Change of use of Existing Butcher's shop (A1 Use) to a mixed use of retail and Restaurant/Takeaway units(A1 and A3& A5) with associated internal alterations to provide cooking facility and seating area.

3 BYRON PARADE, UXBRIDGE ROAD, UXBRIDGE, UB10 0LZ.

13TH March, 2021

Introduction

PROPOSED SIDE ELEVATION
SCALE 1:100

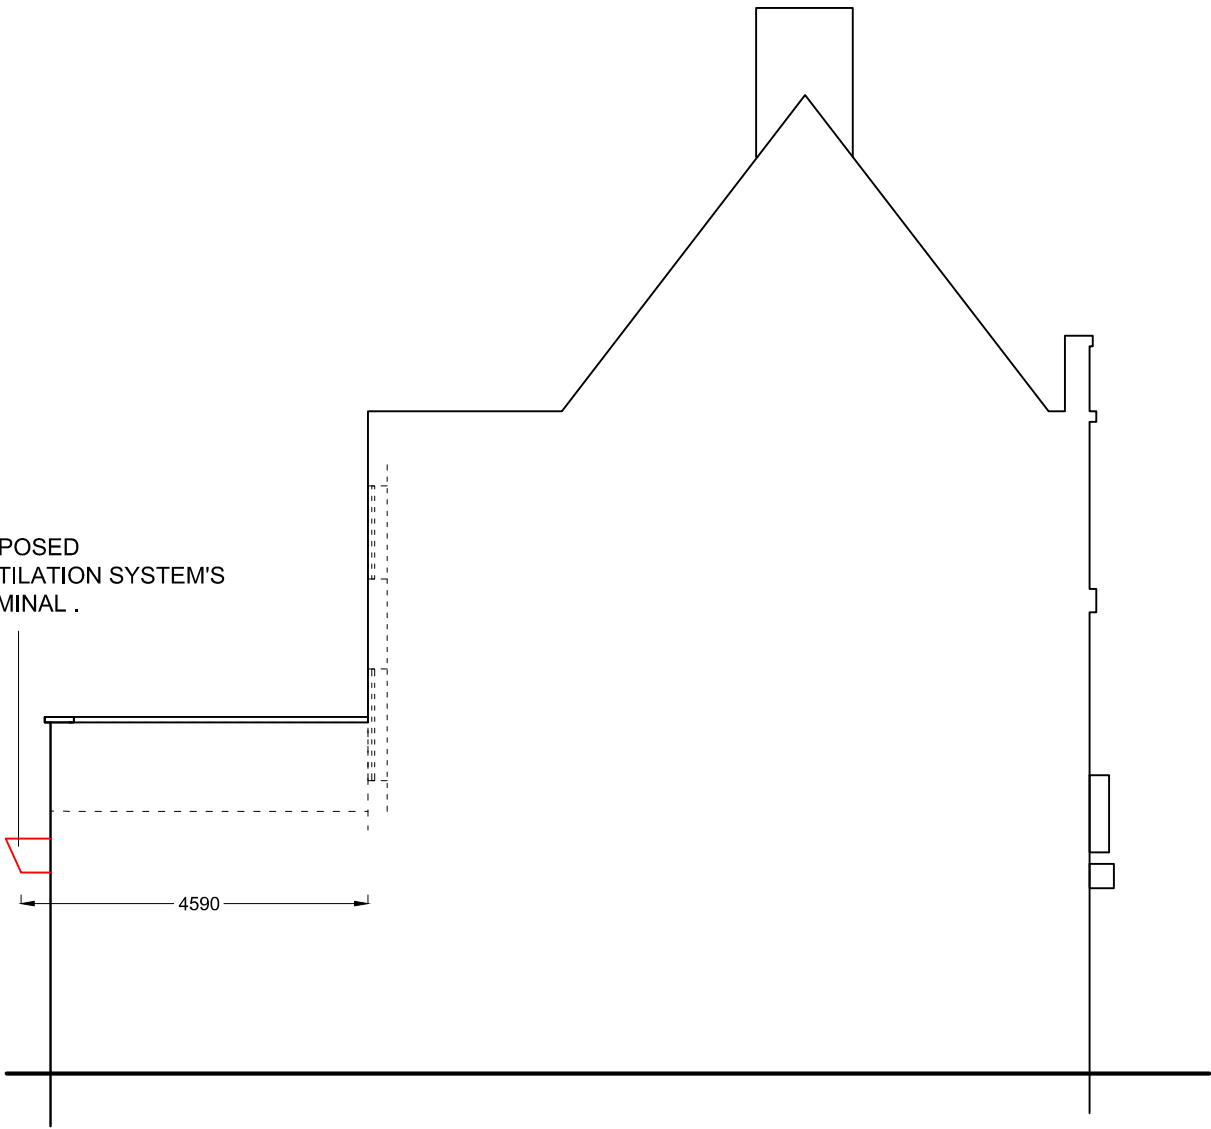
“The proposal, by virtue of the siting and location of the flue and its proximity to adjoining residential occupiers, would be detrimental to the amenities of these occupiers by reason of unacceptable odours, cooking smells, noise and disturbance. The proposal is therefore contrary to Policy DMTC 4 of the Hillingdon Local Plan: Part Two - Development Management Policies (2020)”.

“I have serious concerns regarding the proposed location of the flue and its proximity to the nearest sensitive neighbouring receptors, the drawings do not give a clear indication of this distance and suggest that the terminal point will be horizontal. Given that the main building elevation is (sensitive receptors) is less than 4 metres away the terminal discharge point is too close to residential receptors and hence there is a strong likelihood of odours cookings smells being detected by residents who adjoin that building”

It wasn’t demonstrated in the previous (Refused) proposal that the distance of Terminal Point to nearest sensitive receptor is in excess of 4m, which is now amended as per actual measurement on site and is annotated in the submitted plans with this application and it is believed that the above stated objection is addressed. Also it is worth mentioning that a similar Horizontal Terminal, at the
